WEST SUSSEX COUNTY COUNCIL CONSULTATION

TO:	Arun District Council FAO: Mrs A Gardner
FROM:	Highways, WSCC
DATE:	11/09/2018
LOCATION:	Somerset House, High Street, Angmering, BN16 4AG
SUBJECT:	A/106/18/PL Change of use of the Old Bakery to be used as a self contained annexe for family dependents (applicant's parents) & a holiday let, plus the construction of a new vehicle crossover & off-street parking for 2no cars - This application is within the Angmering Conservation Area.
DATE OF SITE VISIT:	N/A
RECOMMENDATION:	☒ Advice ☐ Objection ☐ Modification ☐ No Objection ☐ More Information ☐ Refusal
S106 CONTRIBUTION TOTAL:	£N/A

client	project	drawing	date	drawn	drawing no	revision
Julie Cleasby	Change of use at Somerset House, High Street Angmering, BN16 4AG	Location & Site / Block Plan	Mar 18	pd	0225 / 101	C
			scale	CAD file name:		
			1:200, 1:100, 1:1250 @ A3

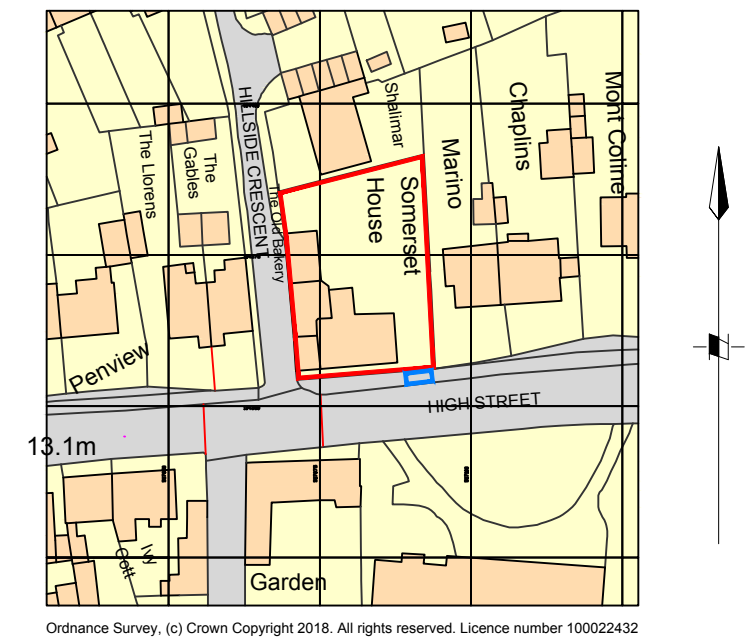
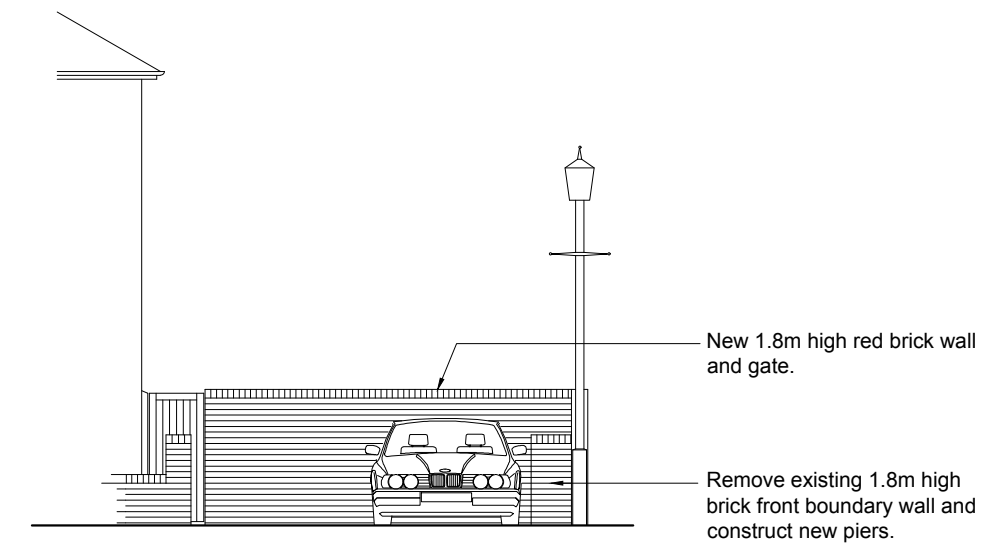
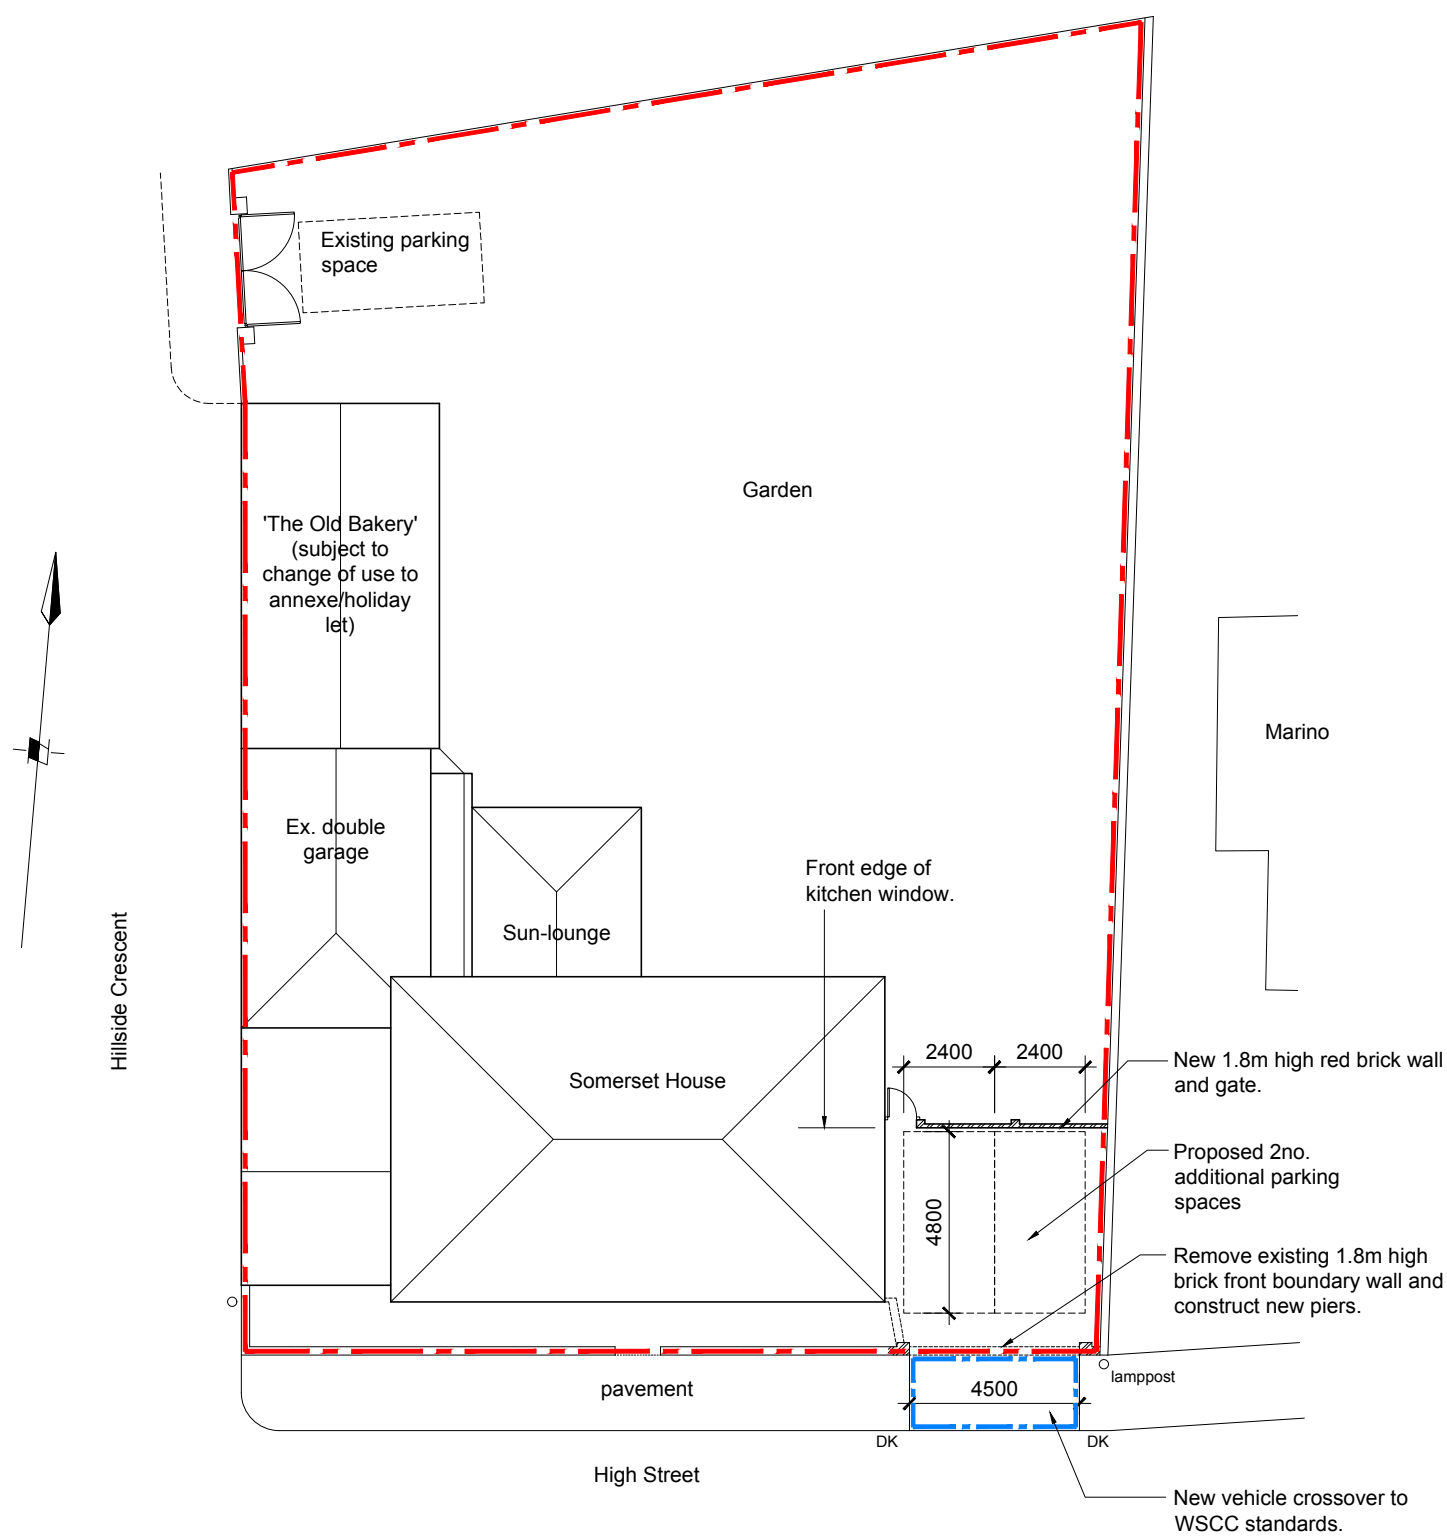
The proposed VCO is approximately 4.5m in width. A license to construct the VCO would need to be obtained from the Local Highways Engineer and must be constructed to a specification agreed with them. The applicant has not demonstrated vehicular visibility splays at the proposed new access. An inspection of WSCC mapping indicates that visibility appears sufficient for the anticipated road speeds; furthermore, due to the presence of on-street parking, vehicles are not anticipated to be exceeding the posted speed limit in this location. An inspection of data supplied to WSCC by Sussex Police over a period of the past five years reveals that there have been no recorded injury accidents within the vicinity of the proposed access and as such there is no evidence to suggest that the addition of a VCO in this location would exacerbate an existing safety concern.

The existing dwelling (Somerset House) has a double garage accessed from Hillside Crescent, a privately maintained road. The Old Bakery is currently used as garaging on the ground floor and business use above. There is also a parking space accessed through the gates to the rear of the Old Bakery building. The change of use to annexe/holiday let would see the loss of the two garages at ground floor and the applicant therefore proposes to replace this parking provision through an additional VCO and two parking spaces off of the High Street. The proposed parking spaces meet the minimum specifications of 2.4 x 4.8m as set out in Manual for Streets (MfS). A turn on site would be preferred although clearly this is not achievable due to the site constraints. Local mapping indicates that neighbouring properties have similar arrangements without evidence of safety concern.
